date August 5, 2019
to Lauren Anderson, Planner
from Jessica Redman, Ecologist
subject Paek Residence – 2215 80th Avenue SE Critical Areas Review

At the request of the City, ESA reviewed the *Critical Areas Study – Watercourse Delineation and Buffer Averaging for: Paek Residence* (prepared by Altmann Oliver Associates [AOA] and dated April 30, 2019). Our scope of work included review of regulations for wetlands, streams, and their buffers; ESA did not review steep slopes or geological hazard regulations. ESA also conducted a site visit on August 5, 2019, meeting onsite with the applicant and City planner Lauren Anderson.

**BUFFER AVERAGING PLAN
 PAKK RESIDENCE
 2215 80TH AVE SE
 MERCER ISLAND, WA 98040**

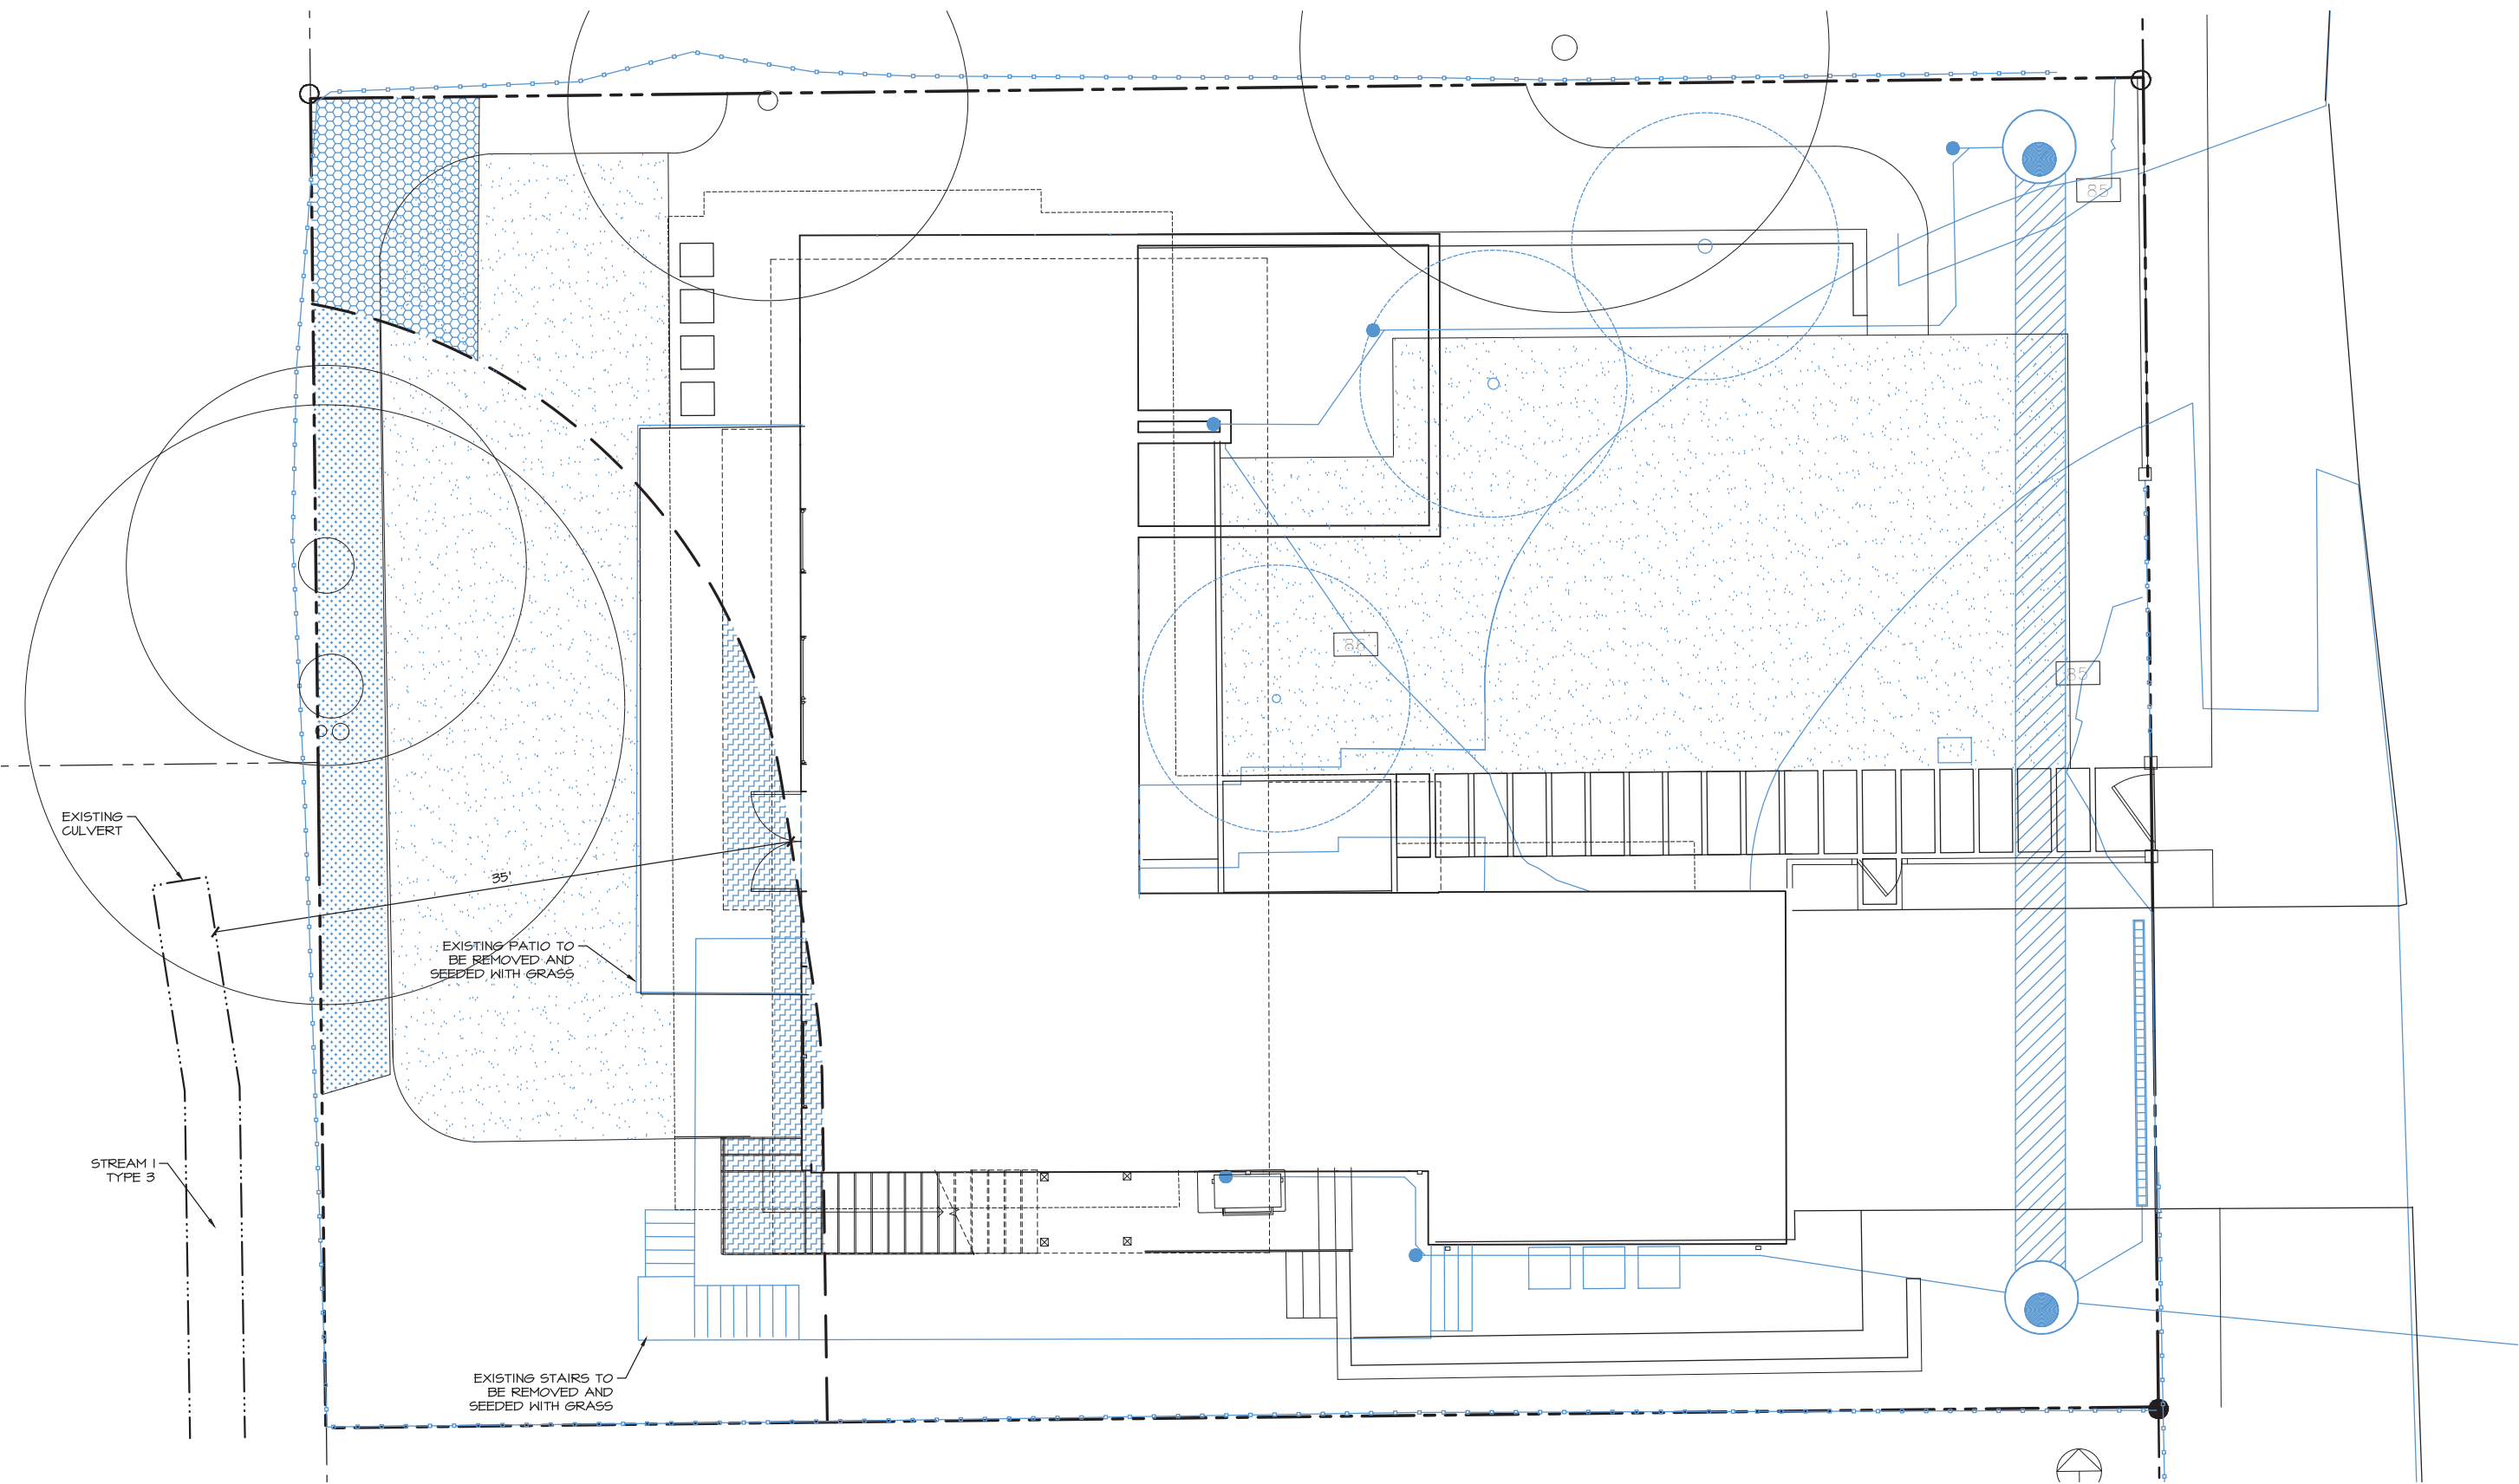
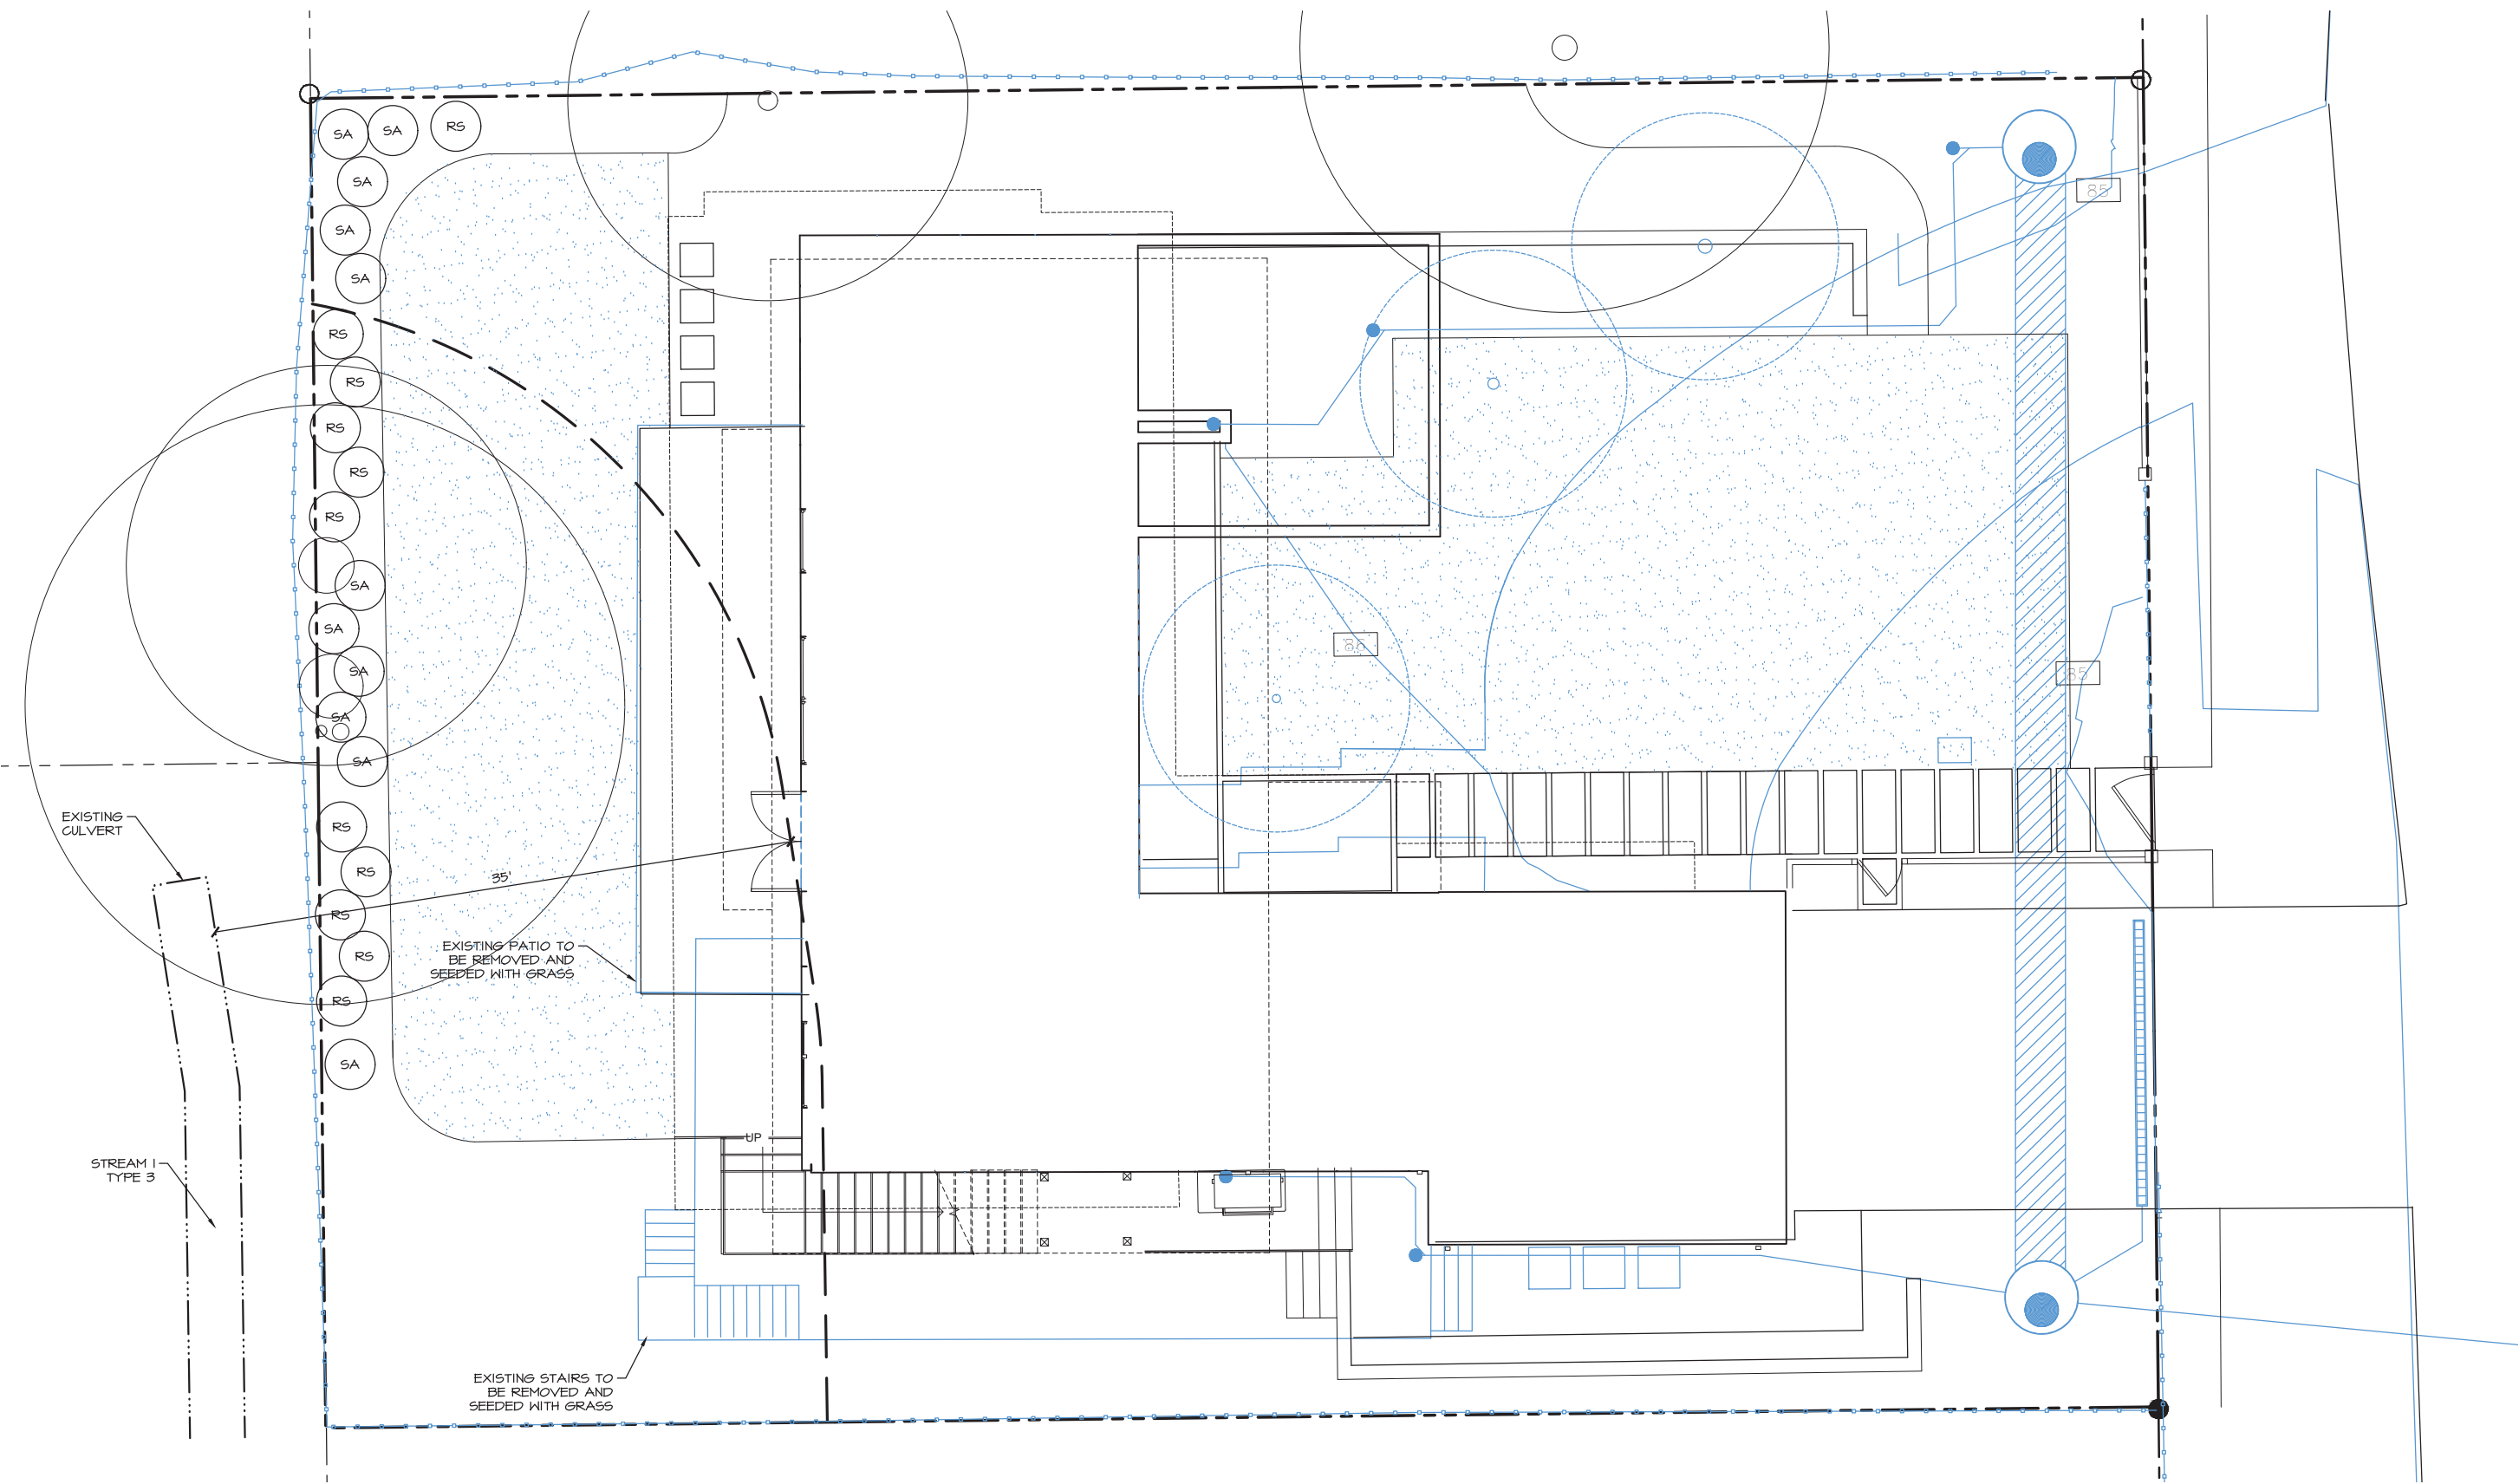
ESA and City staff observed the watercourse from the project parcel during the August 5, 2019 site visit. The watercourse appeared to be a ditched channel that was dug to primarily convey stormwater. No flow was observed during the August site visit. Stream substrate was primarily soil and no fish habitat was observed. Based on the stream characteristics and the location of the parcel near the start of a deep ravine, we also agree that the stream would not support fish and therefore, is a Type 3 watercourse, which would be allotted a 35-foot buffer. ESA did not view the ordinary high water mark (OHWM) of the stream, and therefore, could not locate the exact edge of the buffer in the field. However, the majority of the residence's yard was considered to be in the 35-foot buffer as shown in design drawings provided by the applicant.

During the August 5, 2019 site visit, ESA observed the area of proposed buffer reduction and addition, as well as the proposed area of buffer enhancement. The area of buffer reduction was confirmed to be largely developed. The area of proposed buffer addition as well as the area of buffer enhancement were covered with either grass or bare soil with little native vegetation. No other critical areas were observed on site.

Based on our review of the AOA Report and MICC, as well as the site visit, ESA concludes the proposed buffer addition and enhancement with native plantings will improve buffer conditions at the site and result in an ecological lift in functions. We also agree that due to the small size of the project, annual monitoring of the site should not necessarily be required. However, we recommend that the plants be monitored twice, approximately one year after plant installation (to determine survival and replacement) and five years after plant installation to ensure the mitigation actions of the project are a success.

Therefore, we believe the proposed project has met all requirements for buffer averaging under MICC 19.07.07(B)(3) and is compliant with MICC Chapter 19.07 – *Environment*.
